TfNSW Reference: SYD17/01529/04

Council Reference: SSD 8859

**EXHIBITION OF AMENDED REPORT ON EIS FOR ELIZABETH DRIVE SUBDIVISION
– 1111-1141 ELIZABETH DRIVE, CECIL PARK**

LEGEND		Figure 15: Vehicular Network
	Site Boundary	
	Cadastre	
	Motorway	
	Existing Road Network	
	Proposed 20.0m Wide Access Road	
	Proposed 13.0m Wide Deceleration Lane

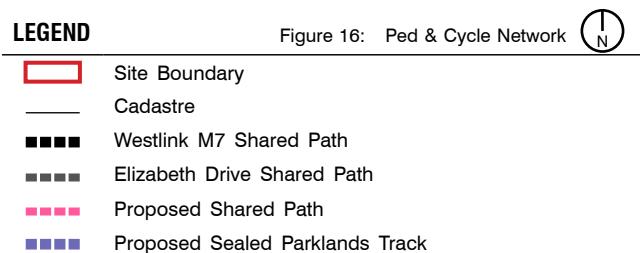
1. TfNSW has safety and operation concerns with the proposed location of the access in relation to the proposed new traffic signals and would not support it for the following reasons:

- a. The proposed access to the site on the new realigned Wallgrove Road is located around a bend and TfNSW raises safety concerns with the sight distance at the proposed access road. A sight distance assessment should be provided to demonstrate the required sight distance is achieved.

- b. The traffic report p.11, shows a proposed left turn slip lane from the realigned Wallgrove Road onto the access road (access to the subject site), which also continues after the access road to form two lanes on the realigned Wallgrove Road continuing to the intersection with Elizabeth Drive. This will potentially cause significant safety and operational issues as traffic turning in and out onto and from the access road would assume these vehicles on the kerb side lane are turning left onto the access road, however, these vehicles may choose to continue to travel straight on Wallgrove Road. Further, visibility and sightlines for traffic exiting from the access road would also be restricted by traffic travelling along the kerb side lane before the proposed access road.

- c. The proposed access to the site is uncontrolled and the potential for conflict is high due to it being at a point where drivers are merging and diverging.

2. TfNSW require the proposed access to the site on the realigned Wallgrove Road to be located to the farthest point of northern boundary of the site, away from the proposed intersection at Cecil Road.
